Comments for Planning Application 23/02758/FUL

Application Number: 23/02758/FUL

Address: Land North Of 1 To 16 Sturt Avenue Camelsdale Linchmere West Sussex GU27 3SJ

Proposal: Erection of 9 no. dwellingshouses together with associated access, infrastructure, parking and landscaping.

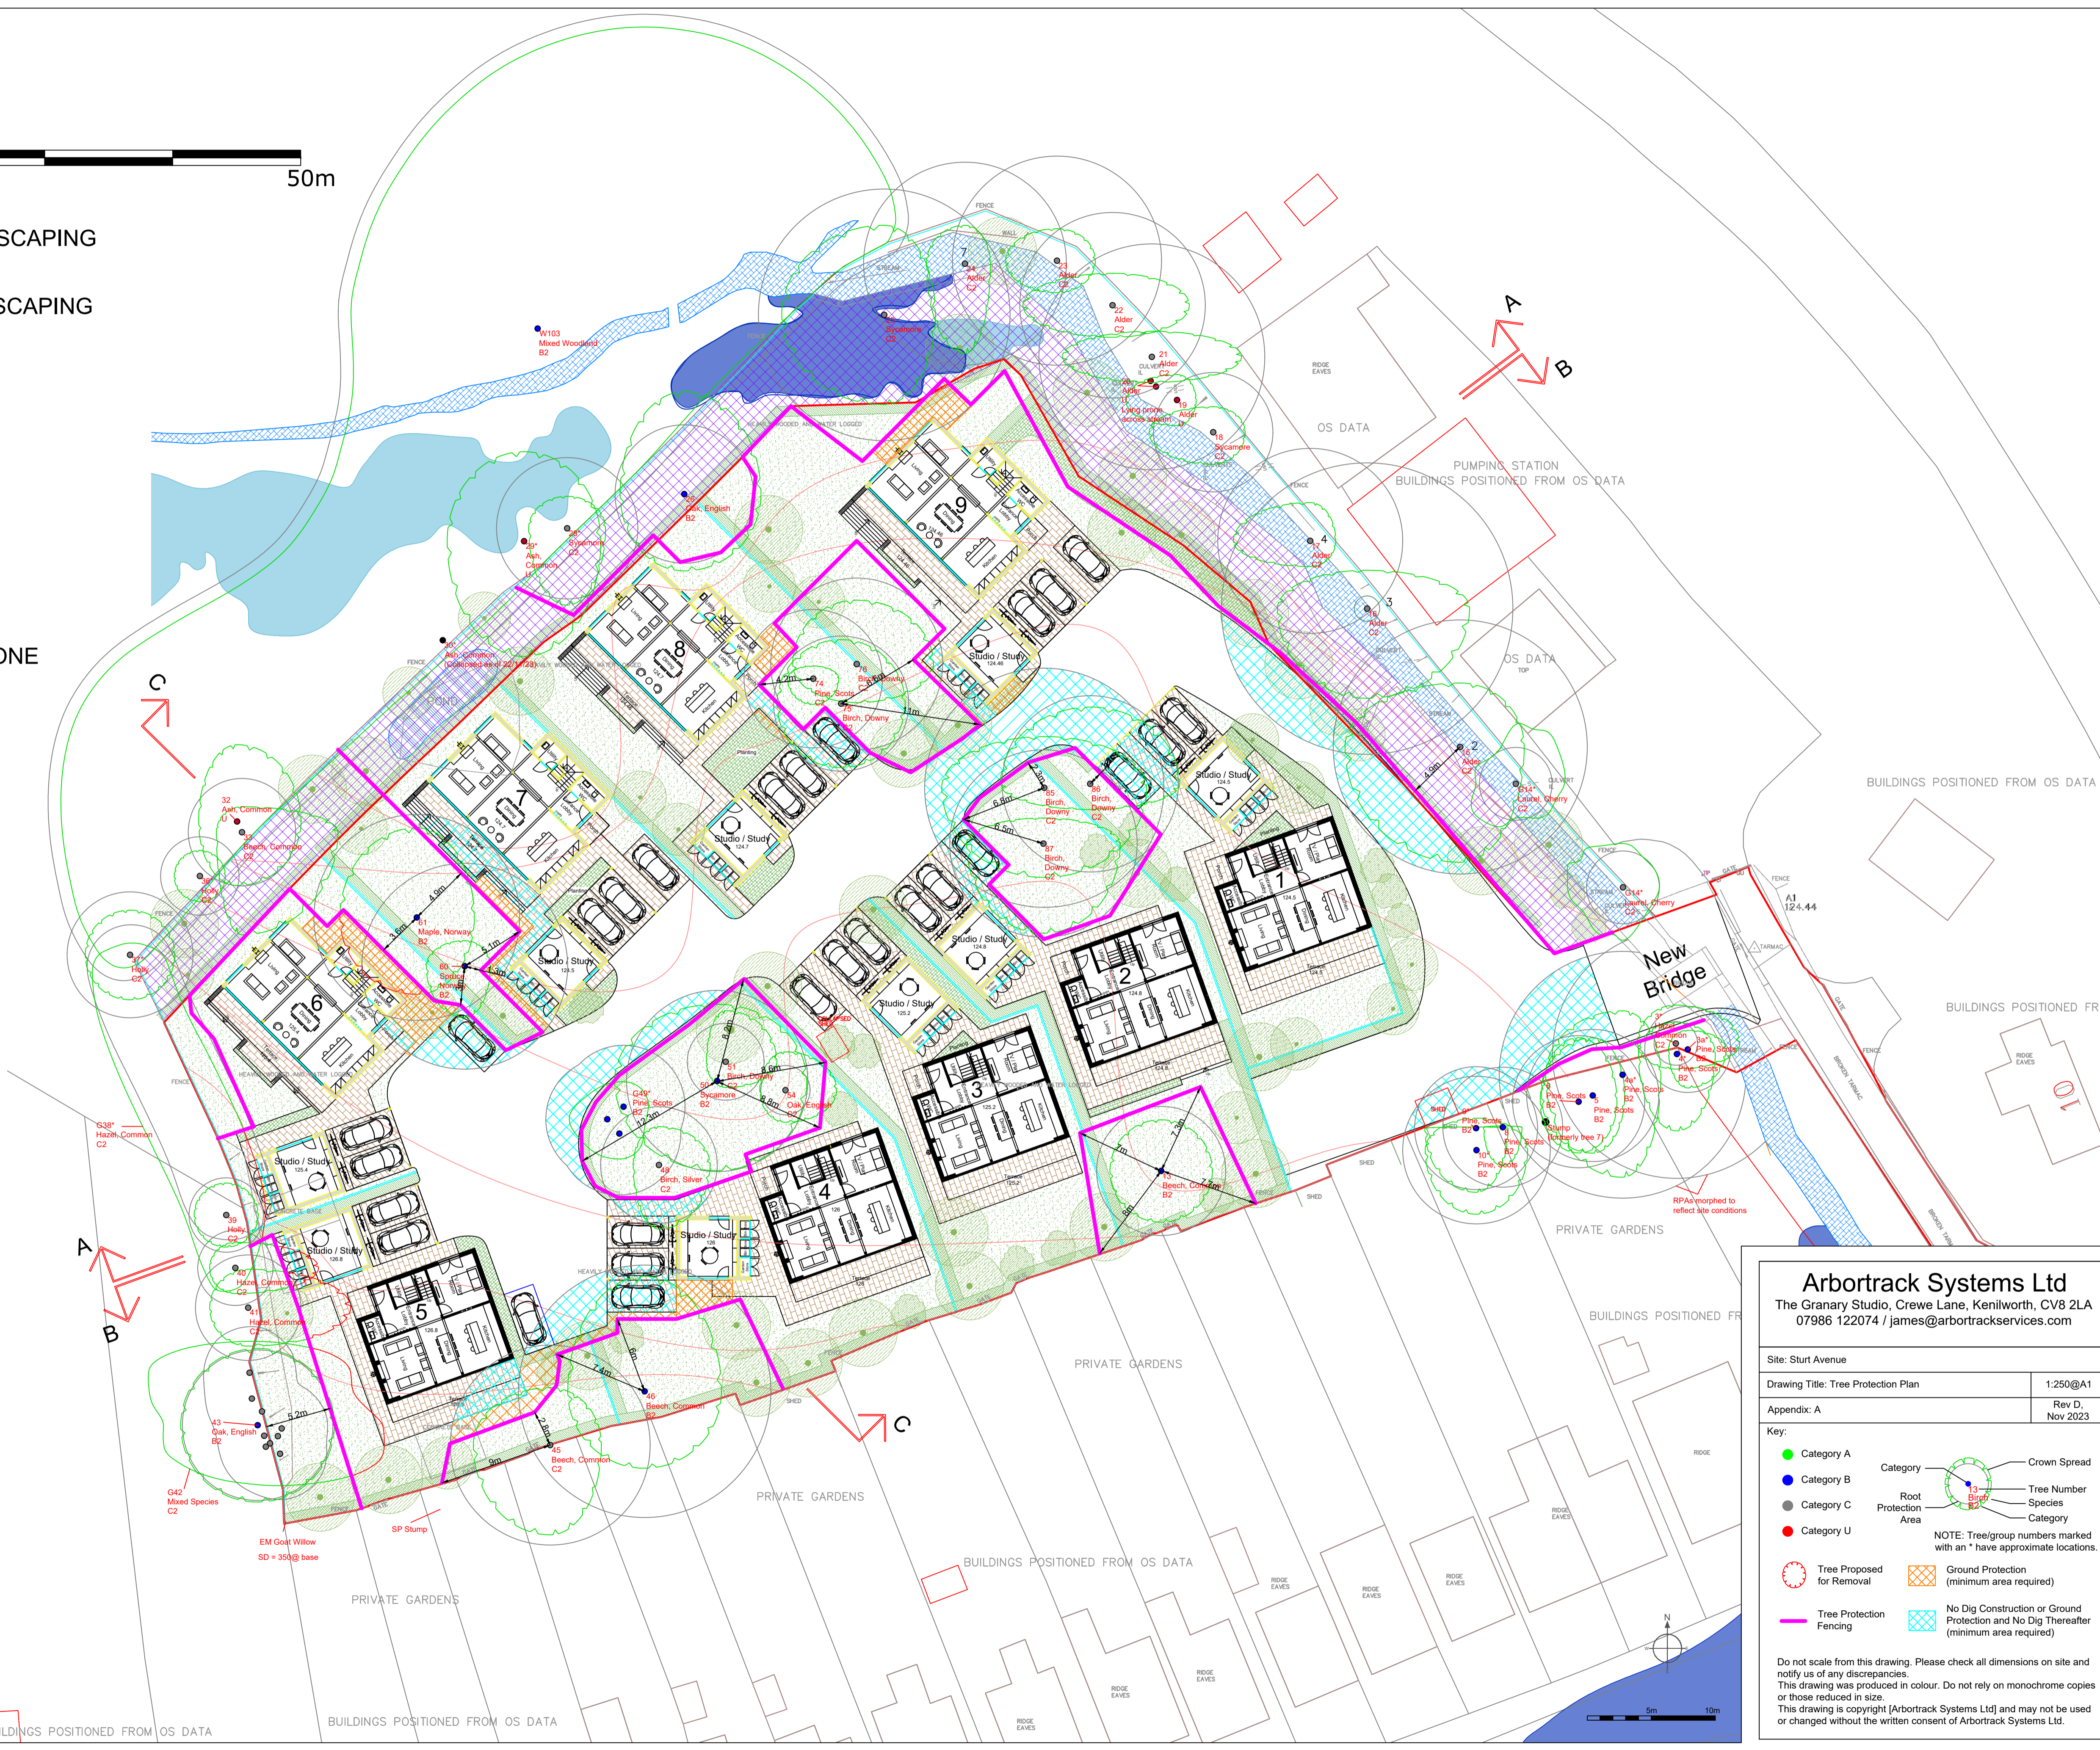
The arboriculturist report, appendix A, does not appear to include the true extent of the root protection zones for trees C15 at 9.9m and C16 at 11.4m. Once these are added to the plan the protection zone will extend across the whole road width. This results in the proposed drainage routes, shown in the drainage strategy, cut directly through the root protection zones for these trees. In addition, telecom, water supply and electrical supply services would need to pass directly through the root protection zones.
